9 March 2009

**APPLICATION TO MODIFY PROJECT APPROVAL NO. 08-0049
SYDNEY WATER FACILITY, POTTS HILL RESERVOIRS SITE**

We make this application under Section 75W of the Environmental Planning and Assessment Act 1979 (the Act) on behalf of Brookfield Multiplex. The application is to amend some of the detailed design and layout of the approved project.

Roof Plan

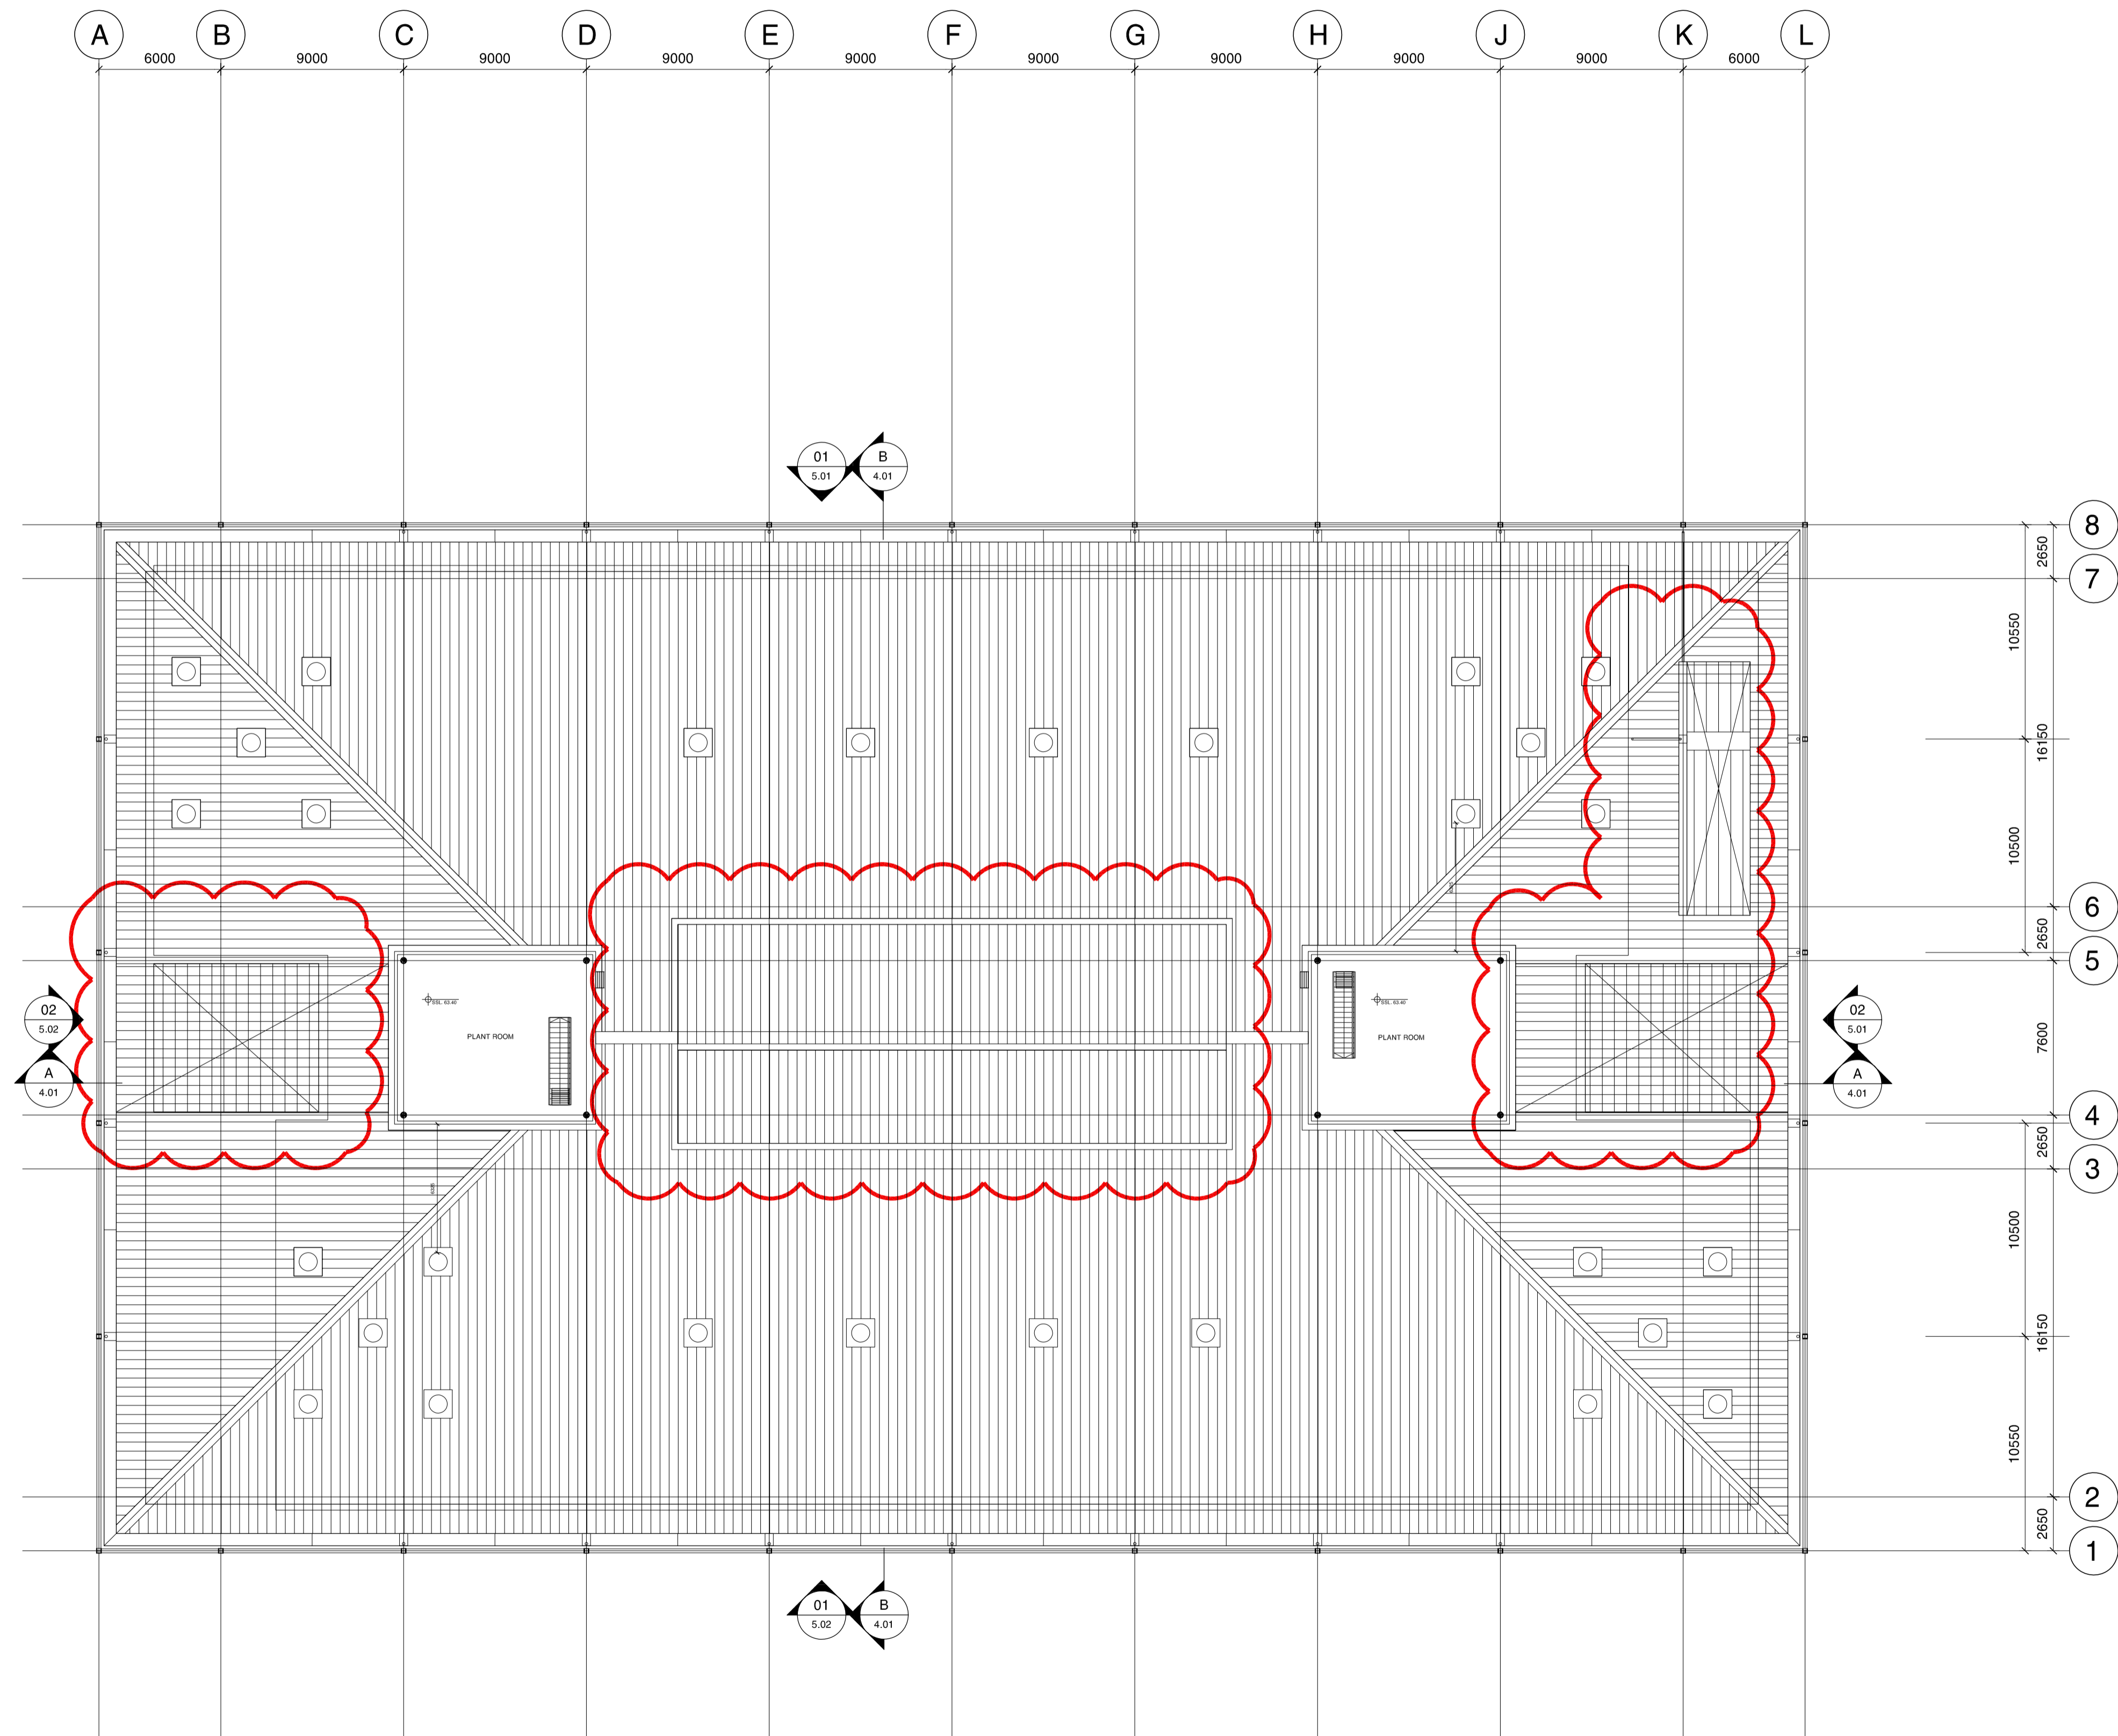
Element	Proposed modifications
Office	• North portion of office extended east by 1.2m and south portion extended west, at ground and level 01 • Enclosed basement added, principally for store rooms, plant rooms, rainwater tanks and the like • North/south dimension reduced • Minor internal layout amendments • Roof design amended and roof level reduced by 515mm

The change in the roof area above the atrium of the office building to a saw tooth configuration has been brought about by the decision to move to a mixed-mode air conditioning system. The plant provides conventional air conditioning as well as enabling natural ventilation. The air conditioning may be shut down and automatic louvers within the saw tooth roof form will open to allow natural ventilation. The proposed amendment is consistent with ESD design principles.

01 Roof Plan
Warehouse Office
1:200

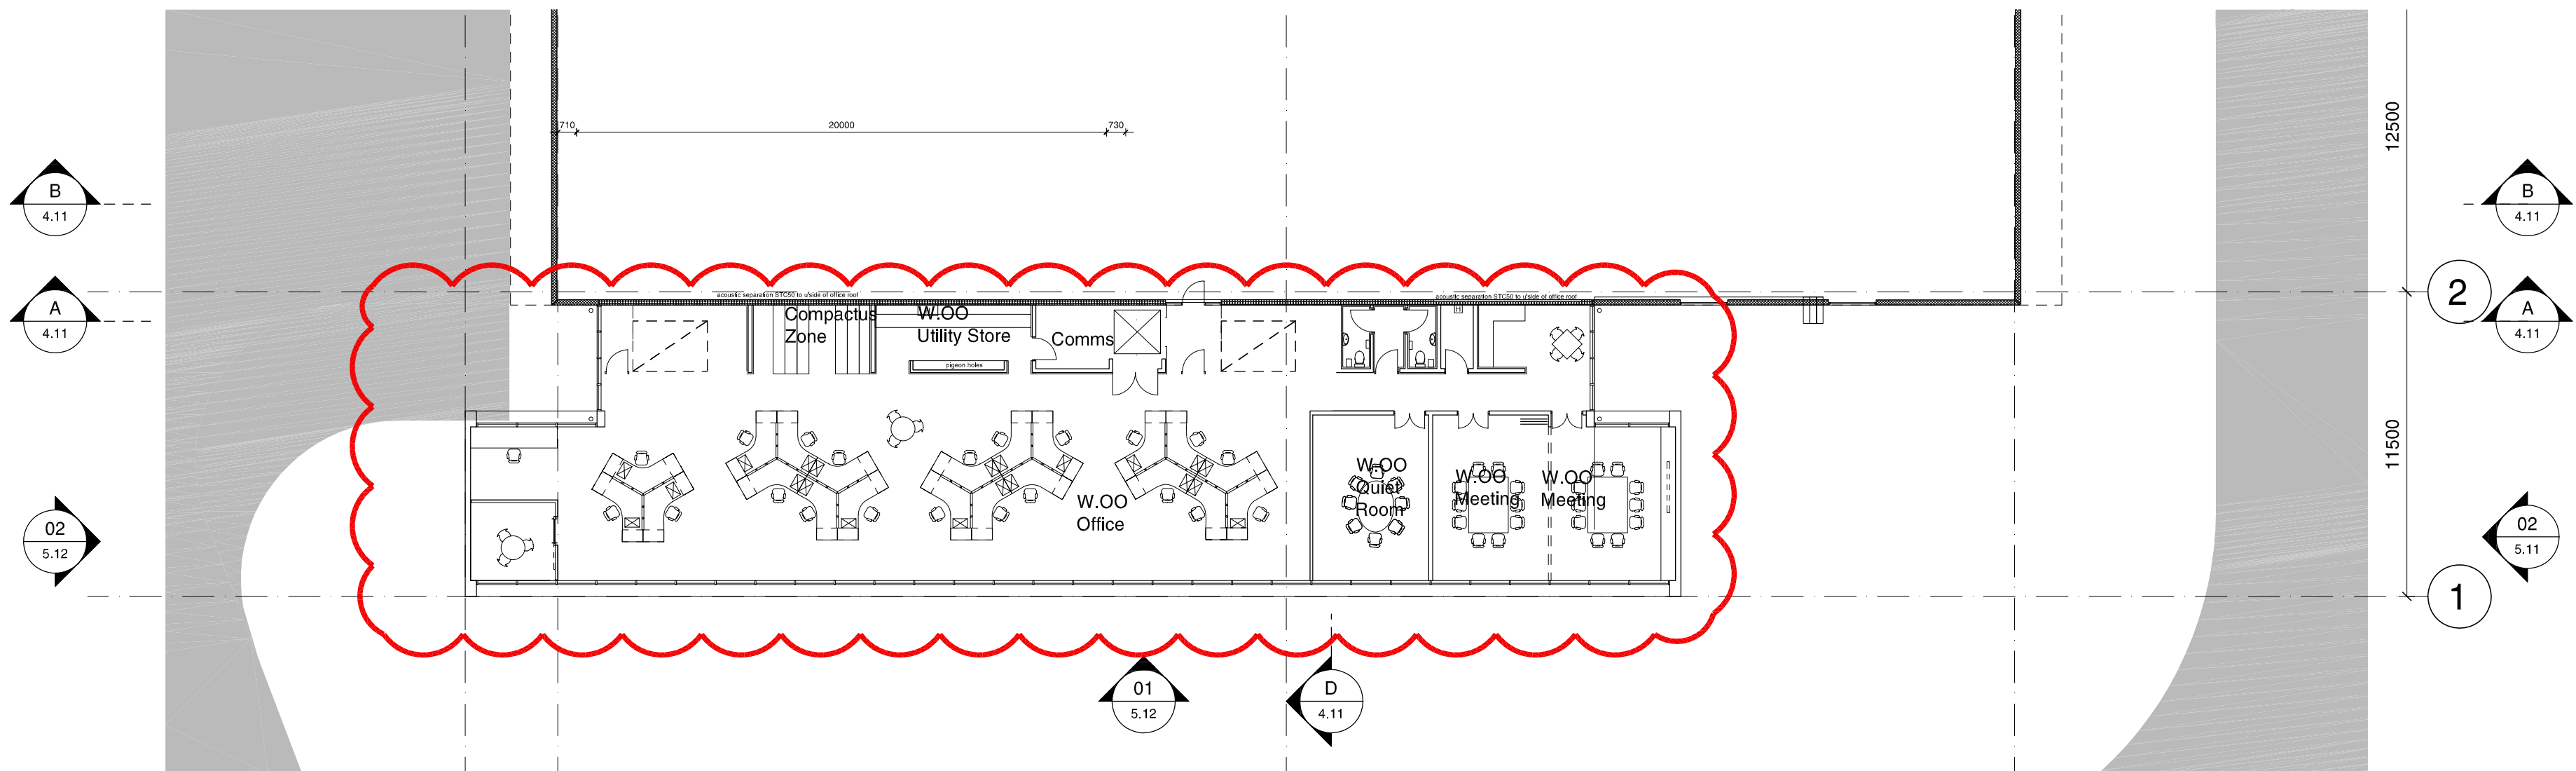
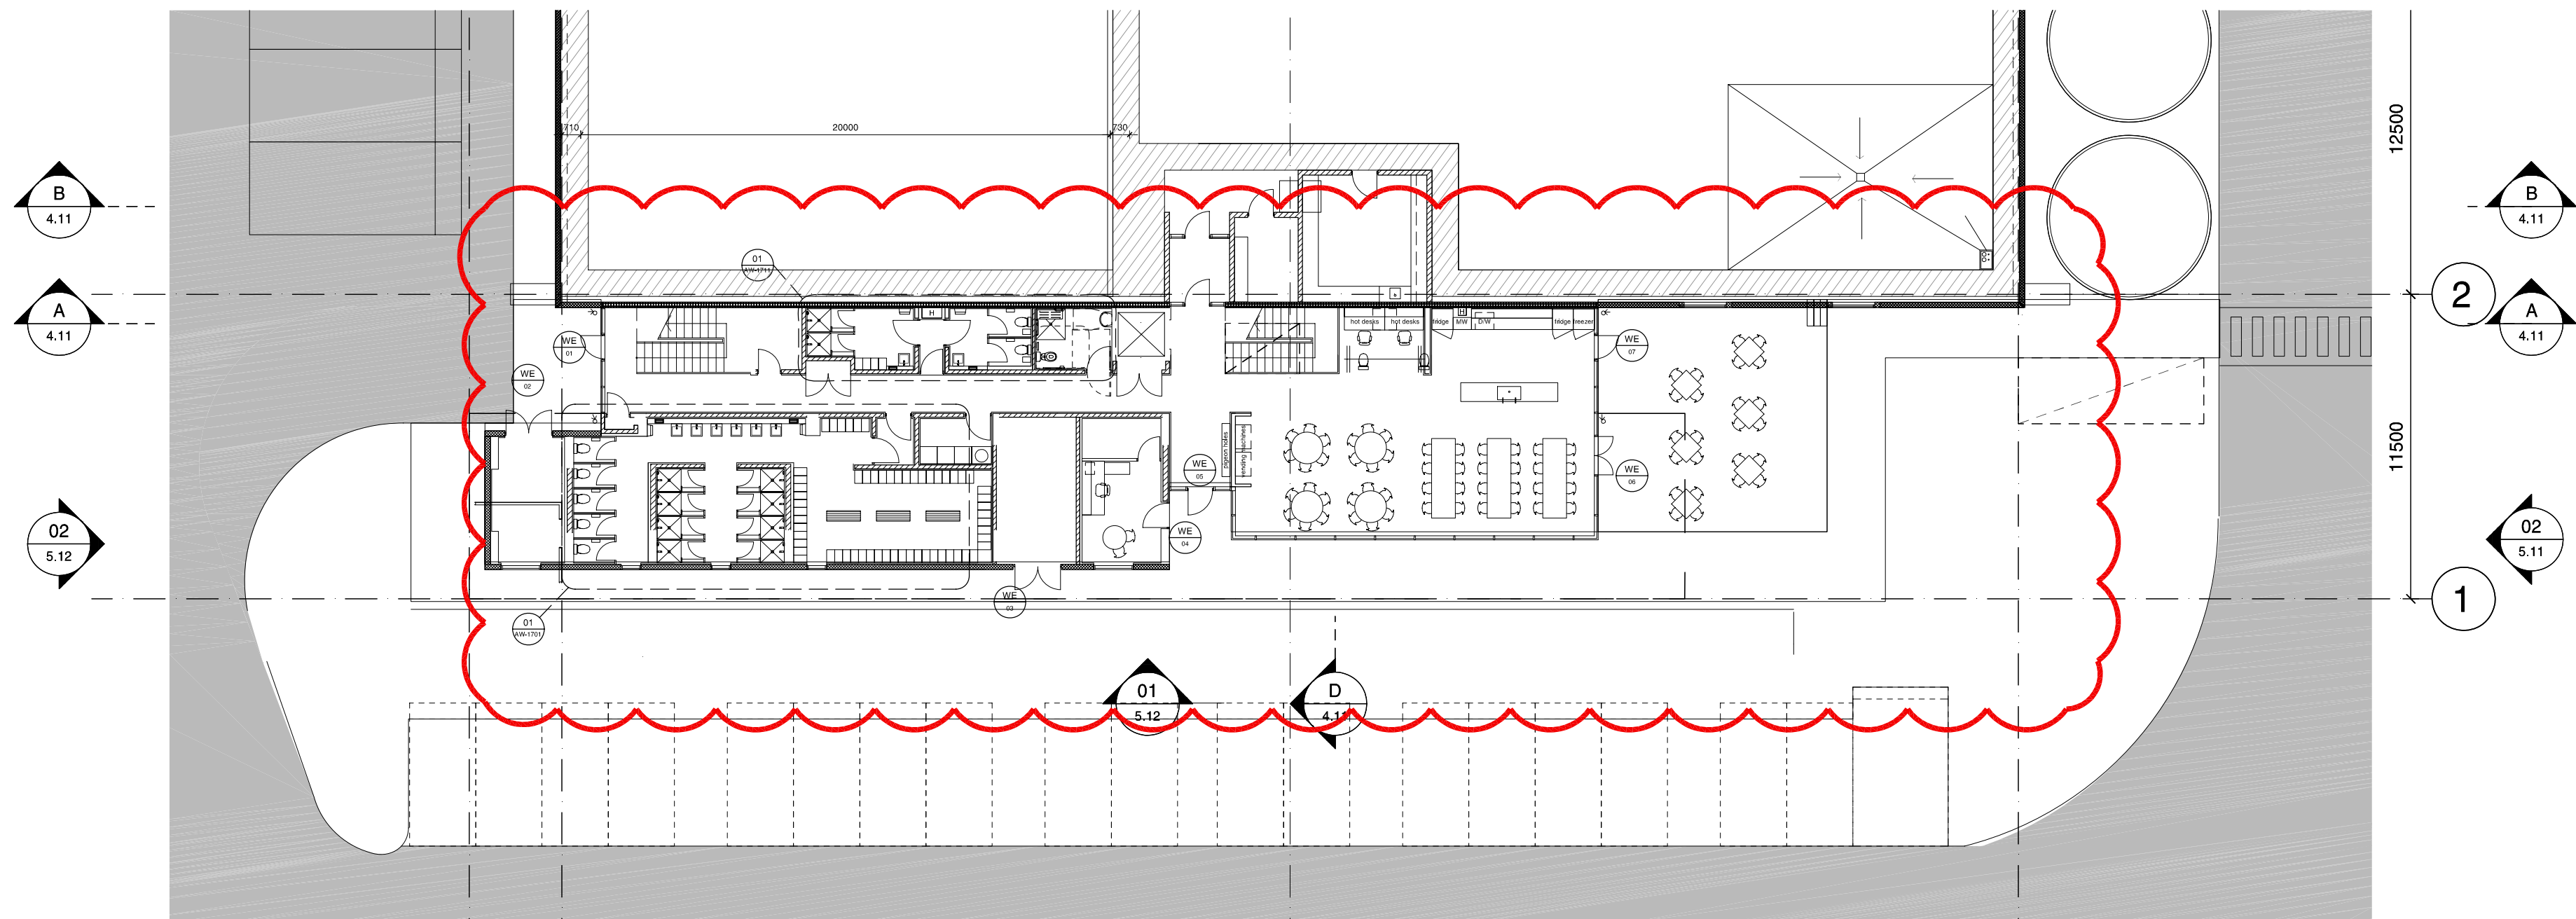
Warehouse/warehouse office	- Warehouse extended north by c. 25m and east/west width increased by 1.2m - Floor levels at warehouse office changed, ramp deleted, lift added - Internal layout of warehouse office amended - Warehouse main roof height increased by 500mm - Precast concrete based added to elevations
Site	- Concrete storage bin layout amended - Above-ground water tanks added at north of site entrance - Truck wash layout amended
Car parking	- Car and truck/trailer layout altered and accessible car spaces included - Number of spaces altered as outlined in following table
Landscaping	Landscaping amended to accommodate layout changes
Stormwater and civil works	More detailed civil works, stormwater and sediment control plans consistent with layout changes and reflecting more detailed construction design
